Our ref: DOC20/1034436-14

Your ref: SSD 10447

**Tomago Resource Recovery Facility and Truck Depot (SSD 10447)**

I refer to your request for advice dated 15 December 2020 on the Tomago Resource Recovery Facility and Truck Depot Environmental Impact Statement.

TYPICAL SECTION OSD / INFILTRATION SYSTEM

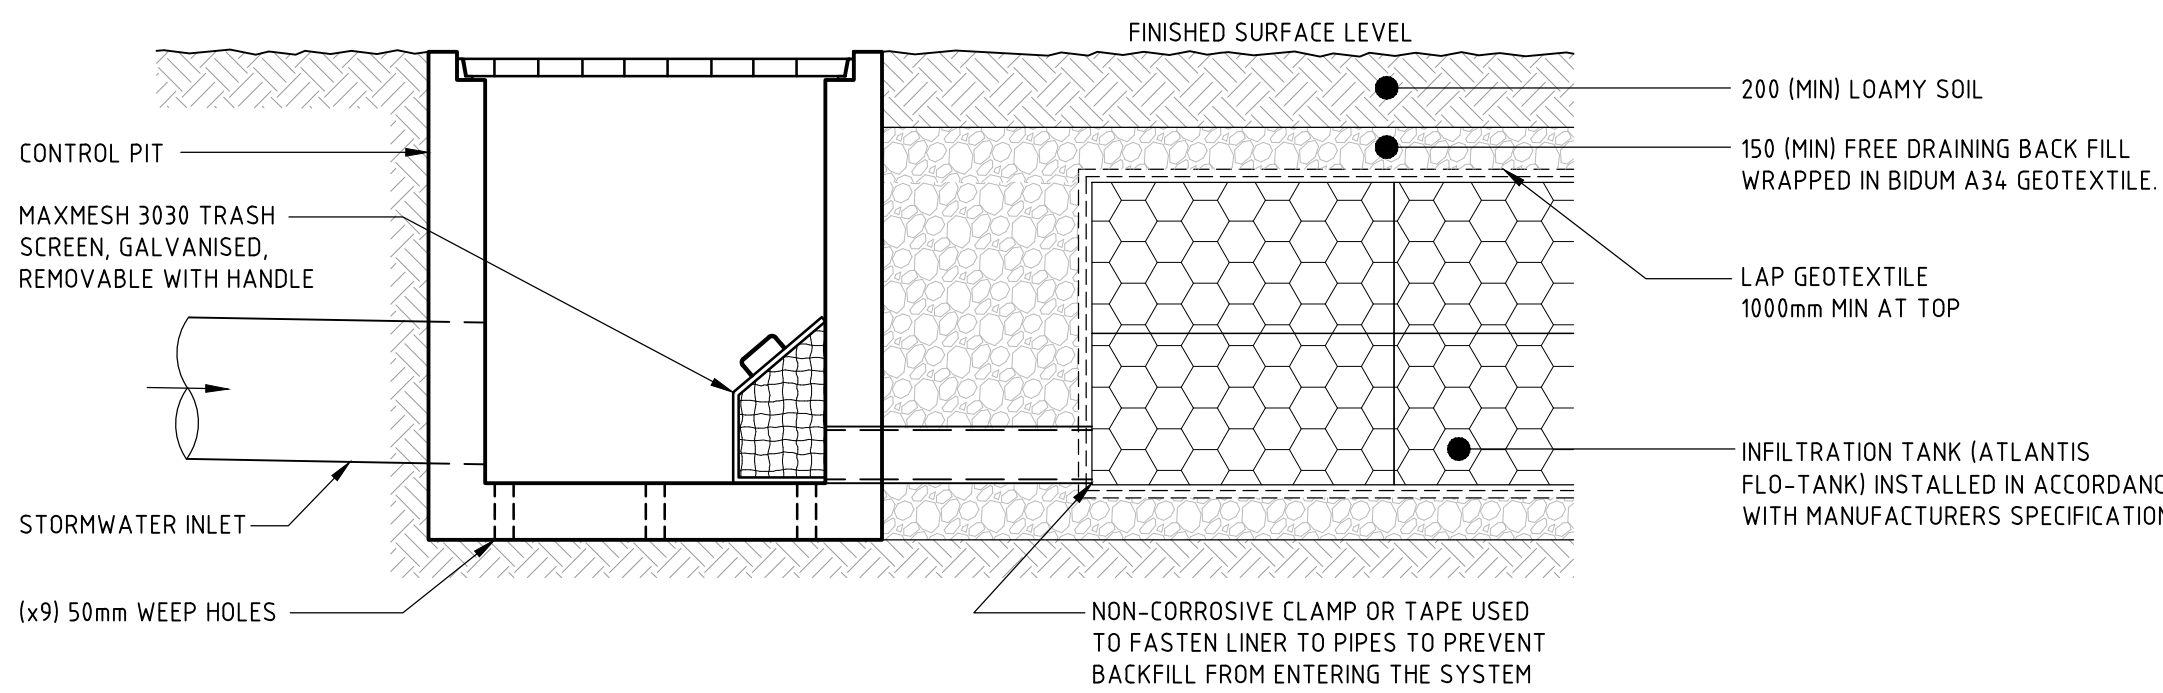
#### 4. It is proposed to infiltrate untreated stormwater to groundwater

Runoff from the existing development enters infiltration on-site detention before it is treated with the Humeceptor STC-5 and the Hume Jellyfish HF-1800 devices. This creates a risk that untreated stormwater runoff will be discharged to groundwater through the detention basins.

The potential for groundwater contamination and impacts on groundwater dependent ecosystems was assessed for the previous development (GHD 2012). However, this assessment cannot be used for this development as it has different pollution risks.

### Recommendation 4

The proponent should consider the potential for groundwater contamination through infiltration of untreated stormwater.
